Case Officer: Gemma Magnuson

Applicant: Bicester Hotel, Golf and Spa

Proposal: Erection of new building to accommodate a new cafe, pro shop, indoor practice room, lockers and viewing gallery

TYPICAL SECTION 1-100

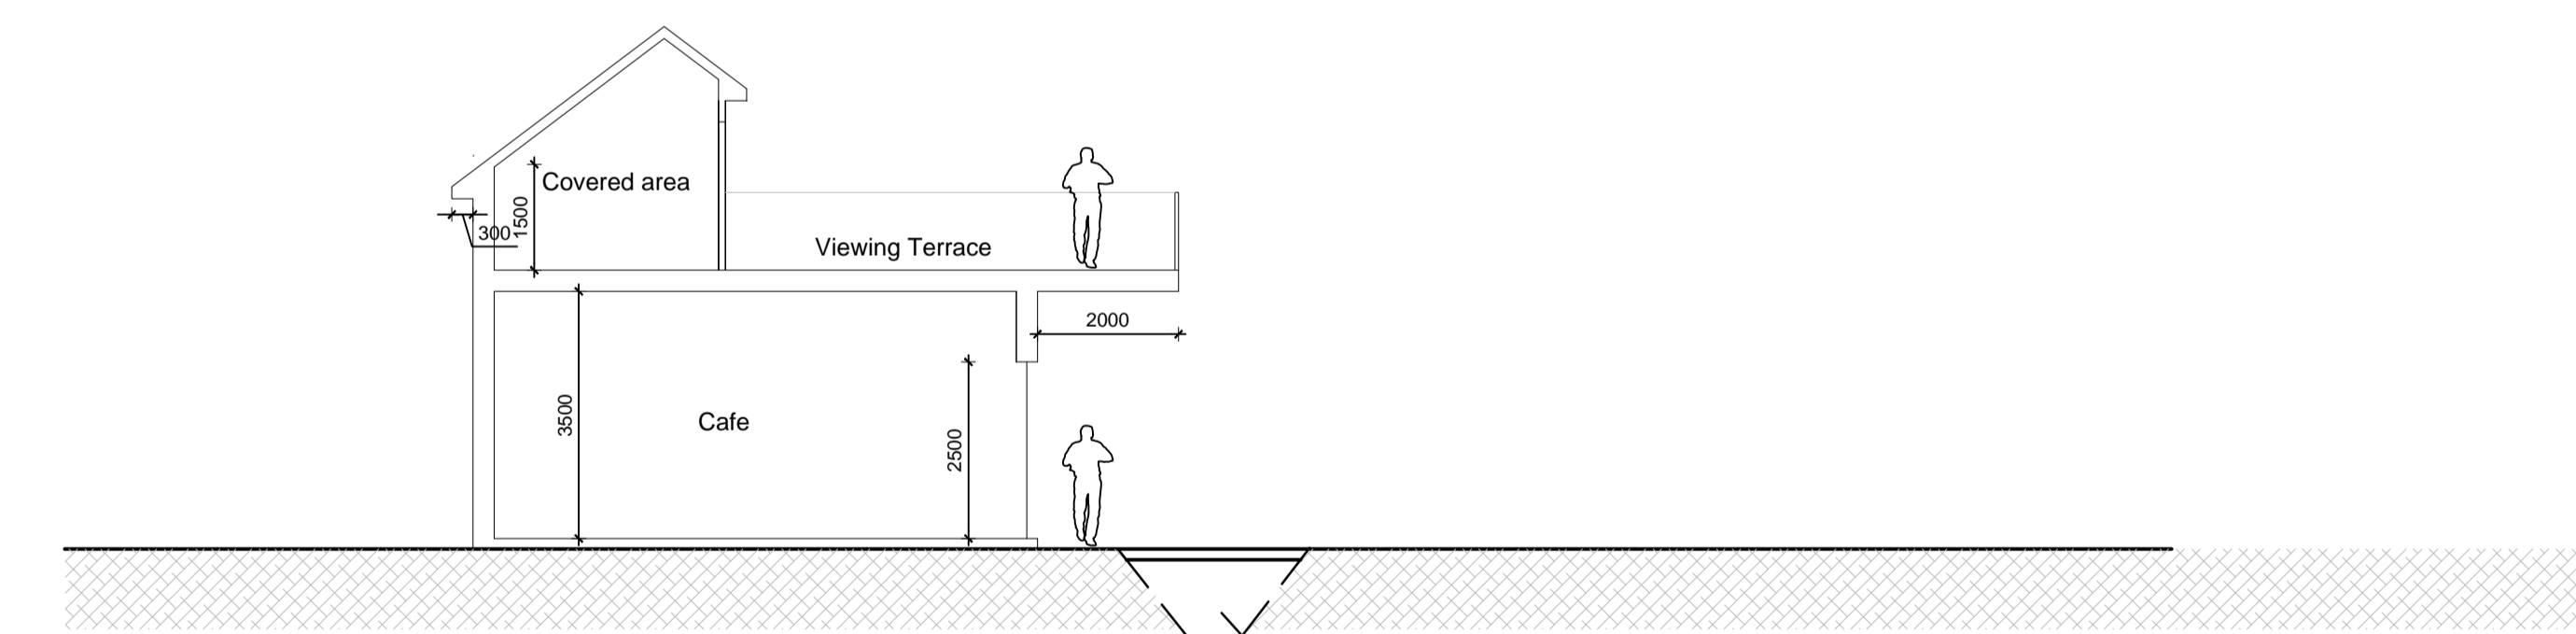
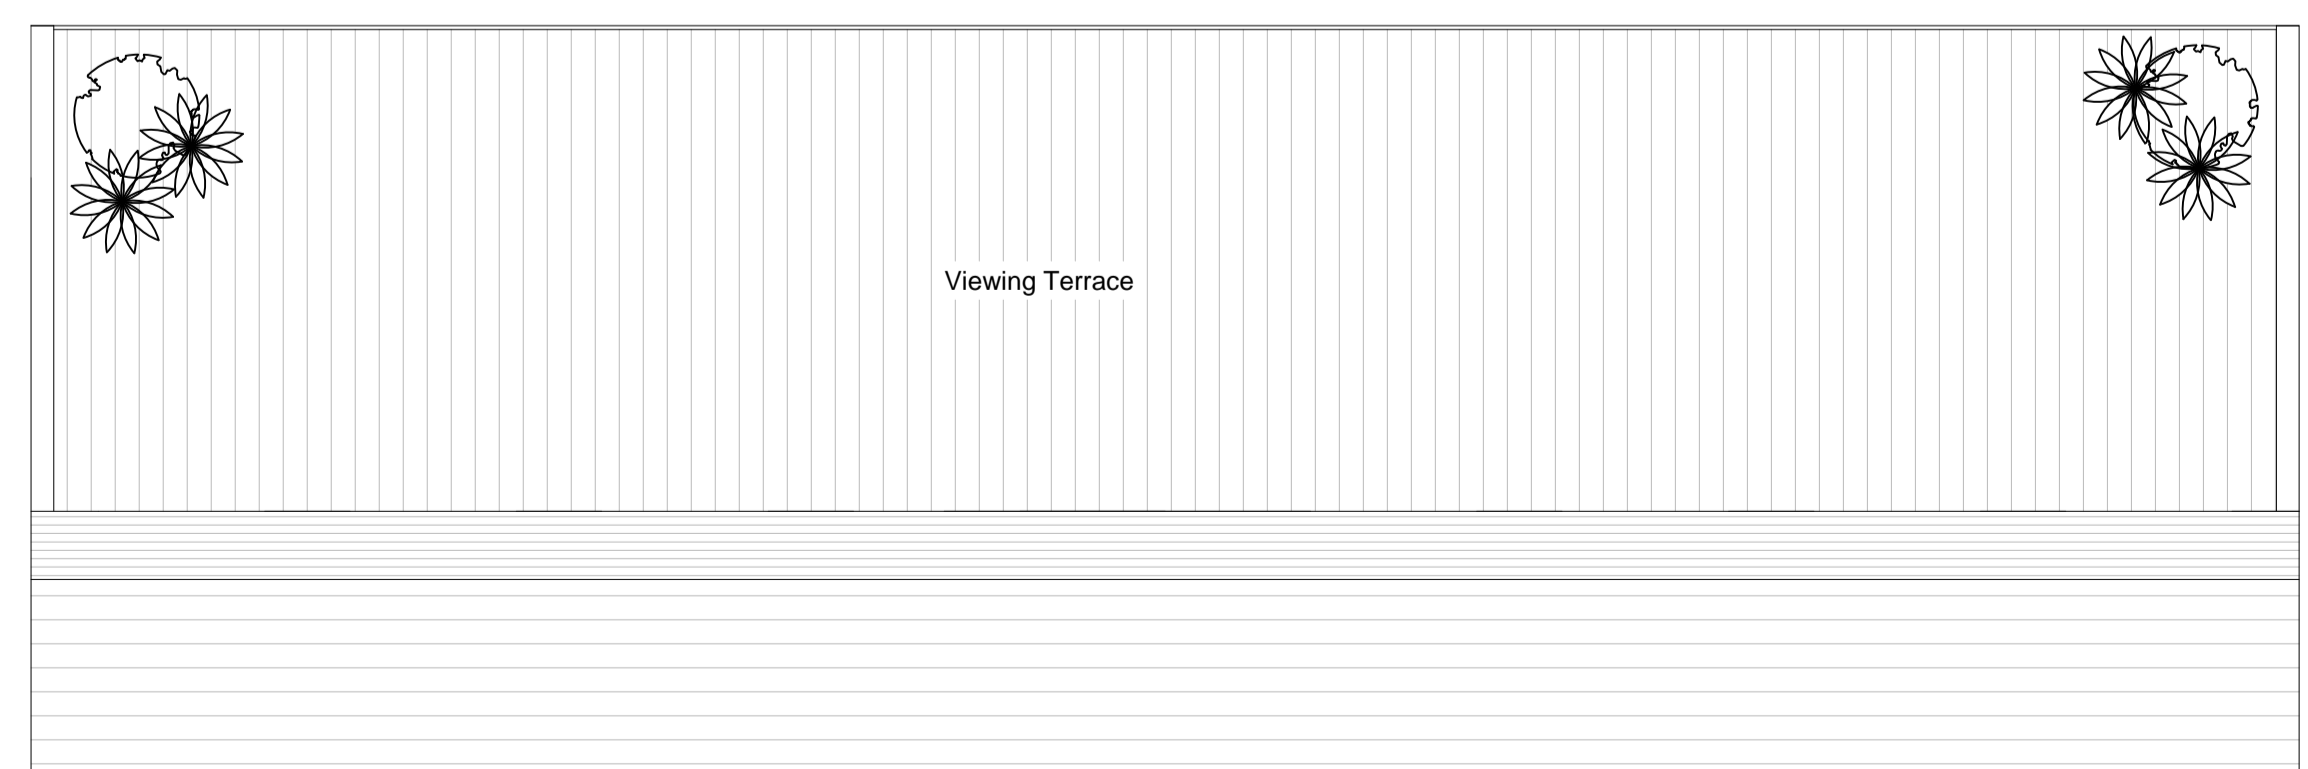
- 6.16. *Light: No comments*
- 6.17. CDC Rights of Way – no comments received.
- 6.18. CDC Licensing – no comment.
- 6.19. CDC Land Drainage - Drainage/Flood Risk. No comments additional to those already made in my response on 18/01/2022. The proposed building will be located over an existing ditch which must be retained, culverted or diverted to maintain continuity between upstream and downstream. If culverted, the culvert size must be consistent with the section of the ditch and anyway not less than 300mm diameter. A Land Drainage consent will be needed for any culverting in addition to any Planning Consent obtained. A Land Drainage consent application should be made showing details of the culverting including the headwalls at each end..

8.19. The original proposal included the infilling of the existing ditch, although the plans have since been amended to avoid this. The Land Drainage officer is content with the scheme and I have no reason to disagree with this. I therefore consider that the matter of drainage has been addressed and that the development would not result in an increased risk of flooding elsewhere, in accordance with the above Policies.
